Waterloo Estate (South) Concept SSDA, SSD-93222706

ptc. has been engaged by Stockland Pty Ltd to provide traffic engineering services in relation to the proposed Waterloo Estate (South) Precinct Redevelopment (SSD-93222706).

The following letter is provided in response to the traffic related comments received from City of Sydney Council (CoS), dated 2nd June 2026 and Transport for New South Wales (TfNSW), date 3rd June 2026.

Figure 1824: Carpark locations and entries

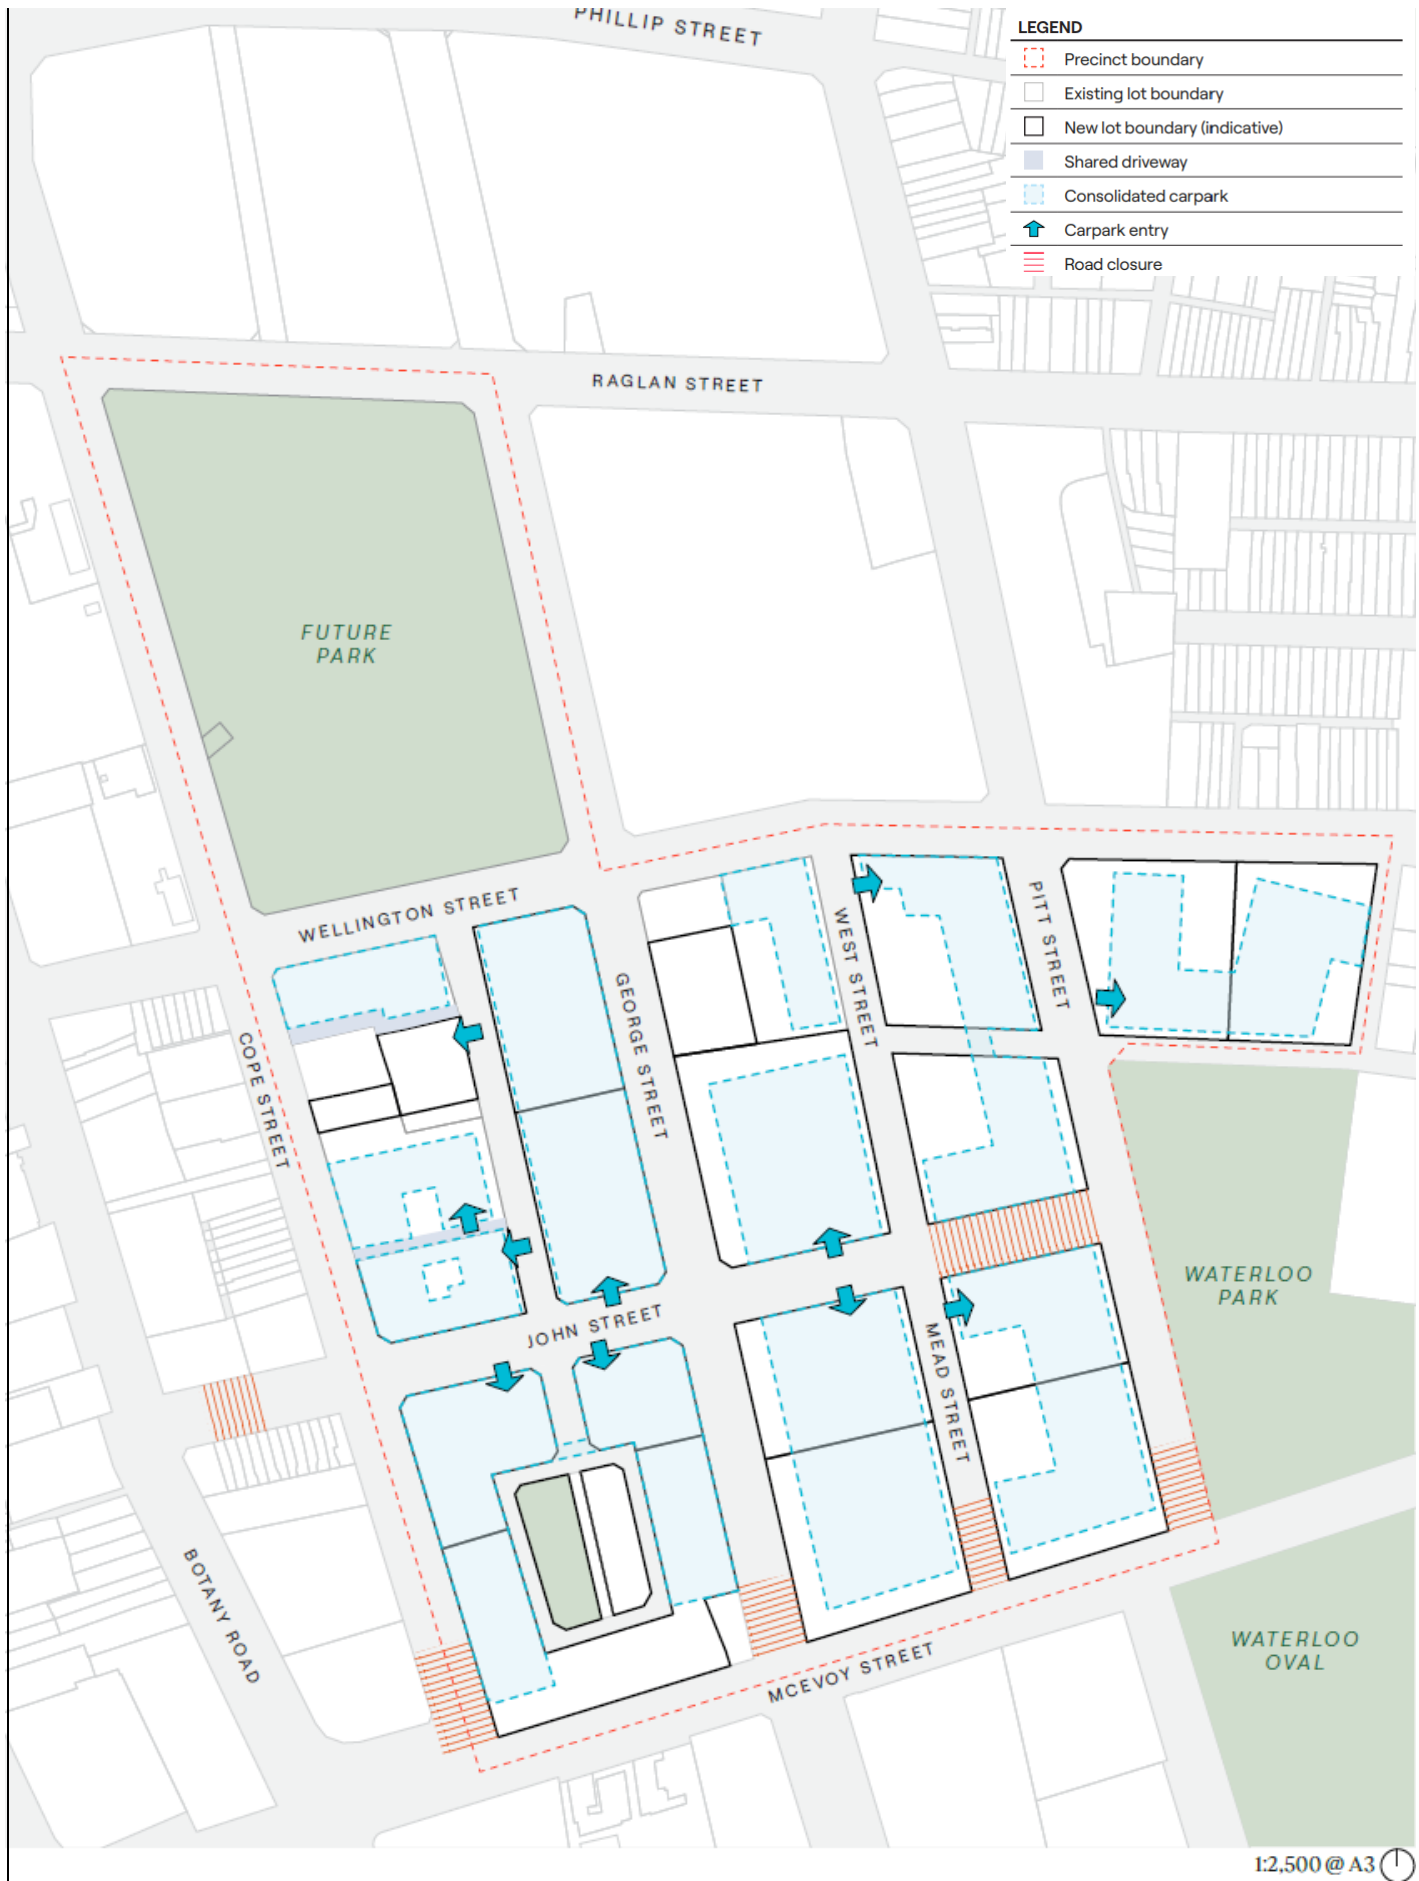
Vehicle Access Locations There are some inconsistencies between the submitted Transport Study and the Design Guide. The Transport Study does not show a vehicle access into Block 4A from West St, while the latter does. Additionally, the Transport Study does not show access into 2A, 2B or 2E, while Design Guide shows two access points. This should be clarified in documentation. Further, the Transport Study indicates that driveways are much wider than driveway widths recommended by the City. Street design should prioritise pedestrian safety and the driveway widths should be reduced as much as possible, preferably to a maximum of 6m. This can generally be achieved by: • Two-way yield driveway: Combining into a single lane serving both entry and exit, with movements controlled via signal. Entering vehicles given priority, while exiting vehicles can wait in a waiting bay. AND/OR • Allowing entering and exiting vehicles to cross the centreline, which allows them to swing wider and enter the driveway from a more perpendicular angle. Vehicle entries should generally be designed in accordance with the relevant provisions of the SDCP 2012, including distance from other driveways and	In response to the comments raised, ptc. have reviewed and modified the block accesses as follows (refer to Attachment 2 for updated Vehicle Access Location Assessment): • Block 2B – Indicative 6m wide driveway shown • Block 2D – 9m wide driveway (due to narrowness of Cooper Street) • Block 3 – Driveway provided 6.5m wide, 8.5m offset from George St TP (min 6m allowed in accordance with AS2890.1 Figure 3.1). and 3.5m from Block 8 service vehicle driveway (set by building form) • Block 4 – Single driveway, reduced to 6.5m • Block 5 – Location determined by building form (driveway width of 9m required due to narrowness of West Street) • Block 7 – 7m wide driveway angle of Pitt St, located 6m from Kellick St TP in accordance with AS2890.1 Figure 3.1 • Block 8 – 2 basement driveways now provided (both 6m wide), 1 service vehicle driveway (6m wide). No access or egress to Cooper Place

<table><tr> <th>Block</th><th>Recommendation</th><th>Notes</th></tr><tr> <td>Block 3</td><td>Offset from Block 8 access location</td><td>Vehicle access is not to be located opposite a busy driveway for a distance of 5m beyond the alignment of the driveway edges or within 15m of the alignment of an intersection where the proposed vehicle access is to be used by service vehicles</td></tr><tr> <td>Block 4</td><td>Consolidate into one location OR narrow and separate driveways</td><td>Block 4 shows two access points: one for service vehicles (10m) and the other for residential parking (7m). These are both excessive and disrupt the pedestrian experience along the footpath. Update to either combine into one driveway or narrow both driveways to 5m and 6m respectively.</td></tr><tr> <td>Block 5</td><td>Location ok, narrow width.</td><td>Careful consideration should be given as to the proximity of the entry location to Wellington Street, promoting unlawful turning. Further discussions with the City are recommended.</td></tr><tr> <td>Block 8</td><td>Entry from John: Consolidate into one driveway and offset from Block 3 access location Exit to Cooper Place: Update Design Guide to show this</td><td>Figure 50 of Transport Study shows that Block 8 relies on vehicle exit onto Cooper Place, however Design Guide only shows vehicle access from John St. The exit onto Cooper Place may be supported but only if safe to do so and in a forward direction. Further confirmation is required.</td></tr><tr> <td>Block 10</td><td>Narrow width of driveway to 6m</td><td>Proposed width is 8m. Swept paths allow for 899 to exit and enter simultaneously, which is excessive, as given slow speeds and low volumes (~50 vph) / hr based on their trip gen rate of 0.14 trips per dwelling.</td></tr></table>
